WEST SUSSEX COUNTY COUNCIL CONSULTATION

TO:	Arun District Council FAO: Andrew Wood
FROM:	Highways, WSCC
DATE:	10 th April 2018
LOCATION:	Rear of 6, Hook Lane Close, Pagham, PO21 3NY
SUBJECT:	P/26/18/PL 1 No. detached bungalow with on-site parking & vehicular turning facilities (re-submission of P/86/16/PL).
RECOMMENDATION:	
S106 CONTRIBUTION TOTAL:	£N/A

sheet 1a of 3

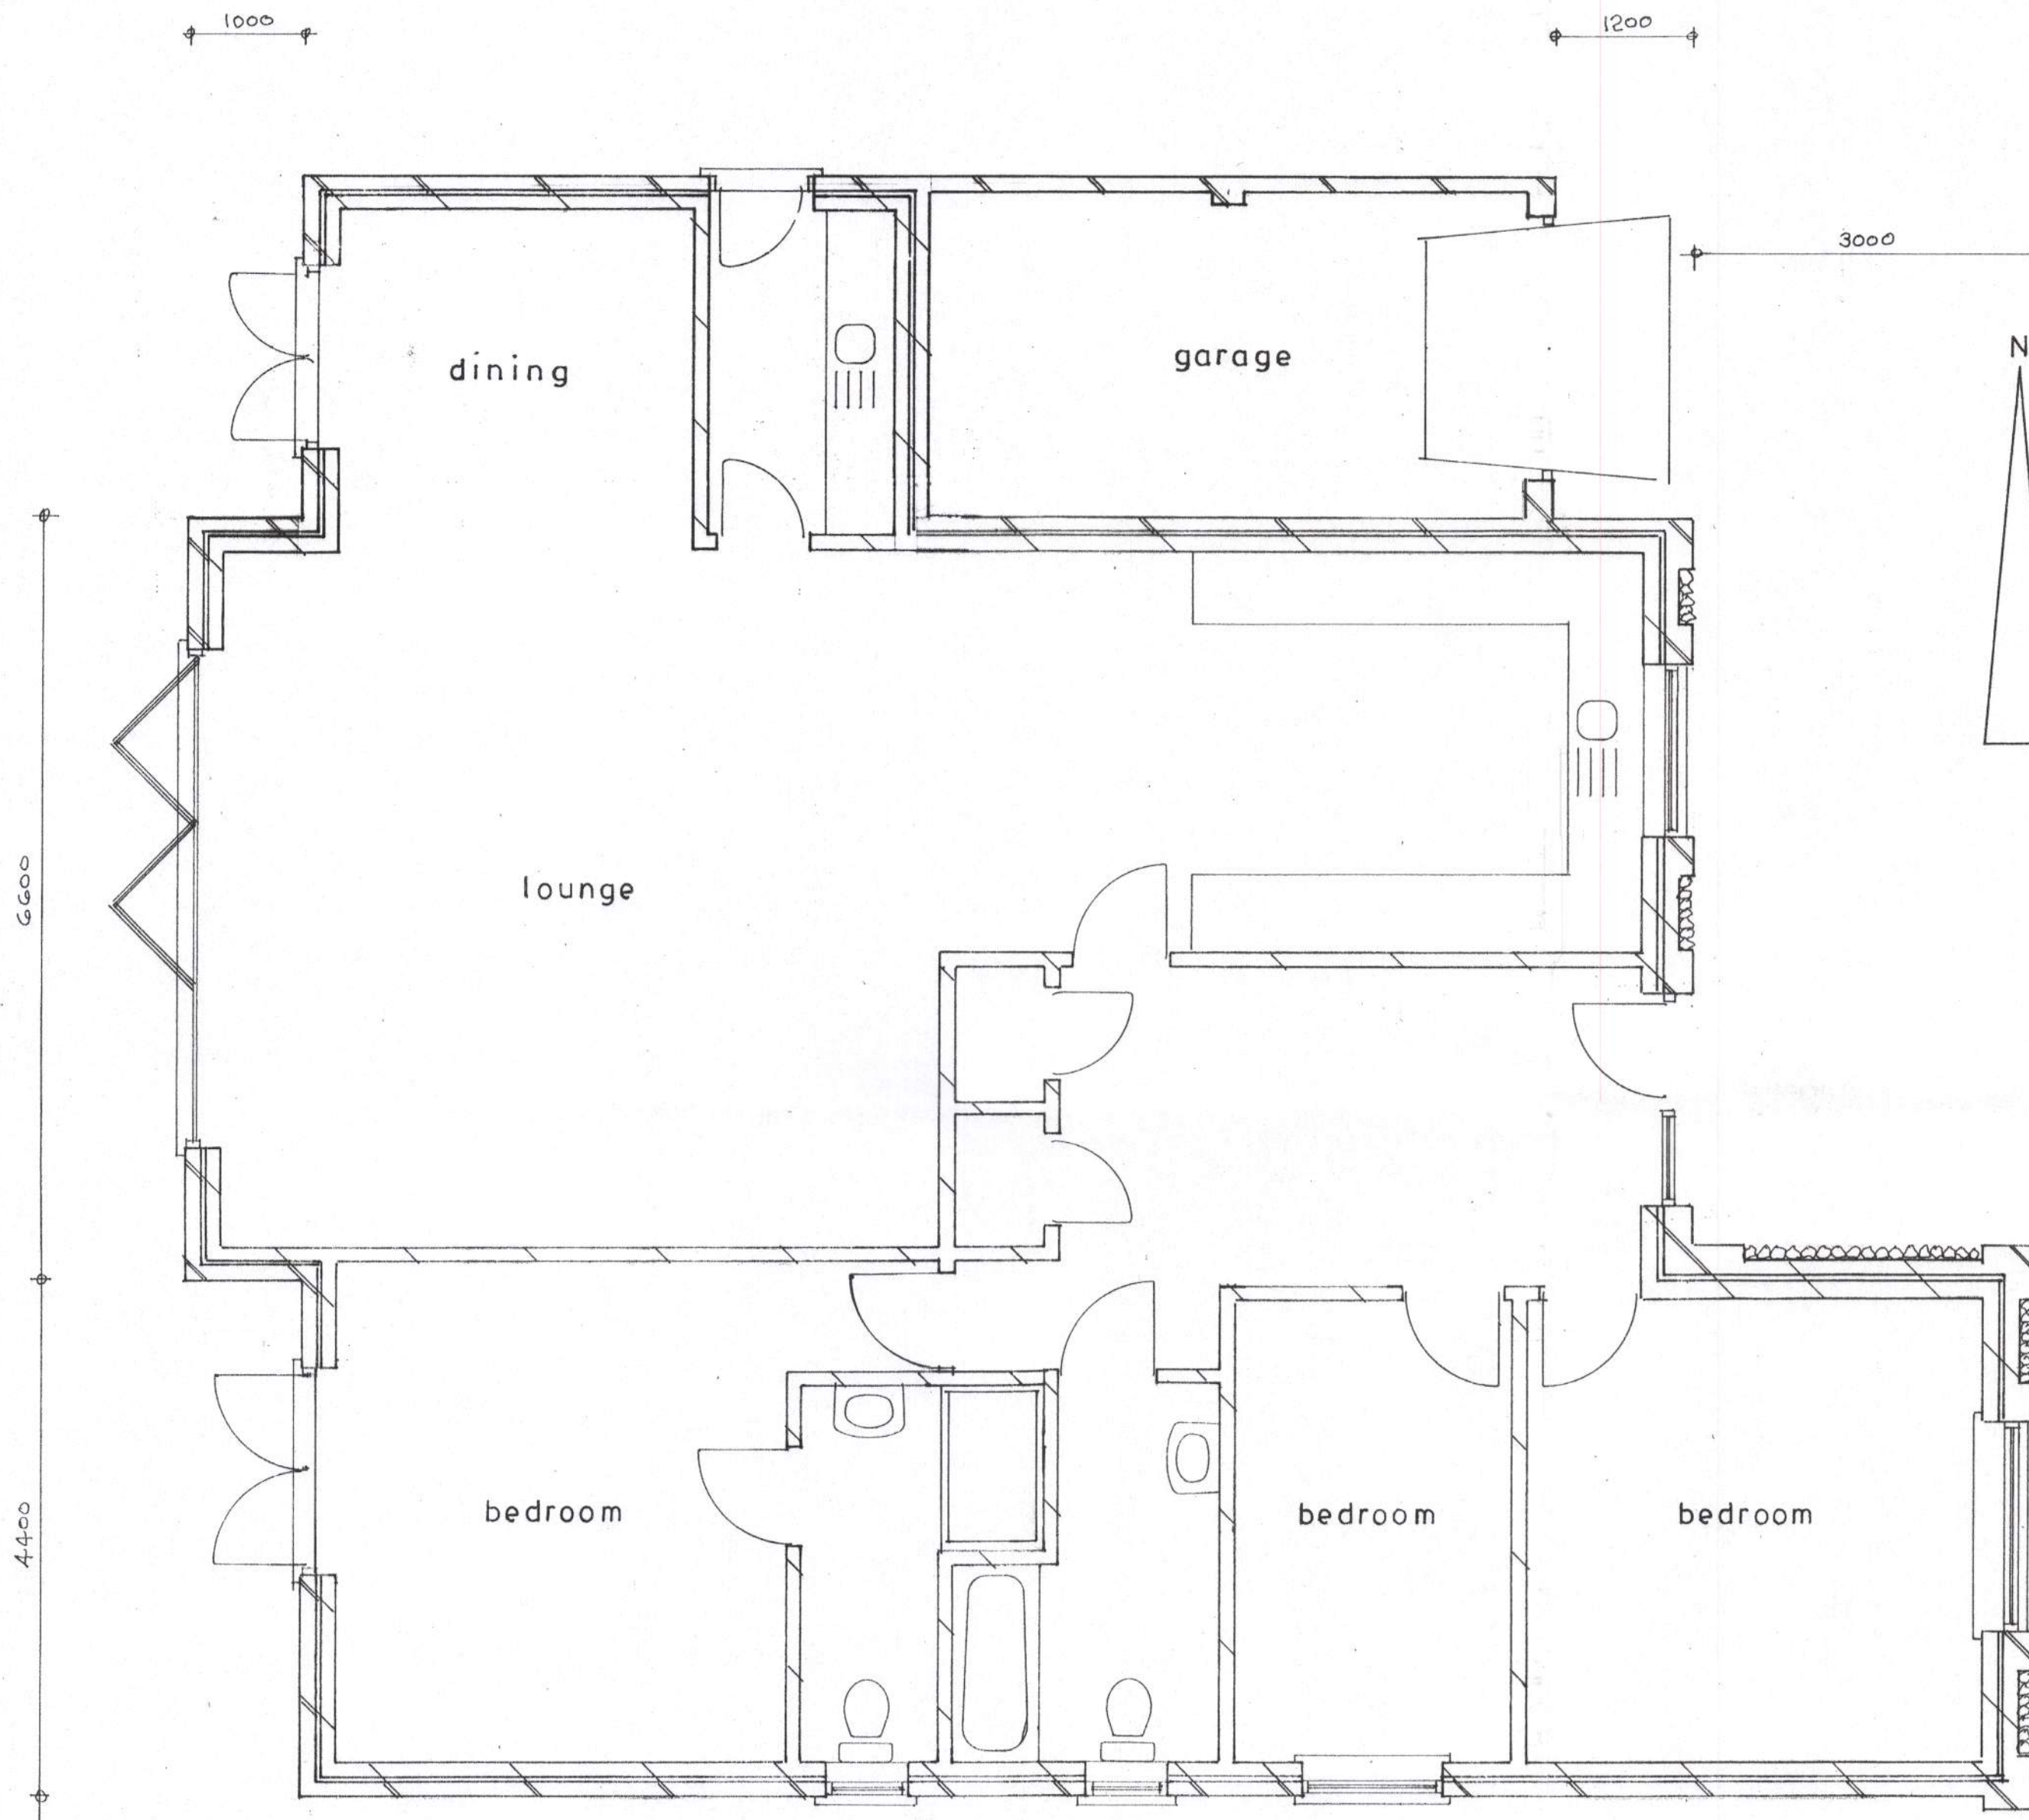
The current application is a re-submission with an amended parking and turning layout. The proposal has been enlarged and the garage repositioned. The location of the proposed parking spaces have altered however an inspection of the plans shows that suitable space for a turn on site will be retained so that cars can exit on to Hook Lane in a forward gear.
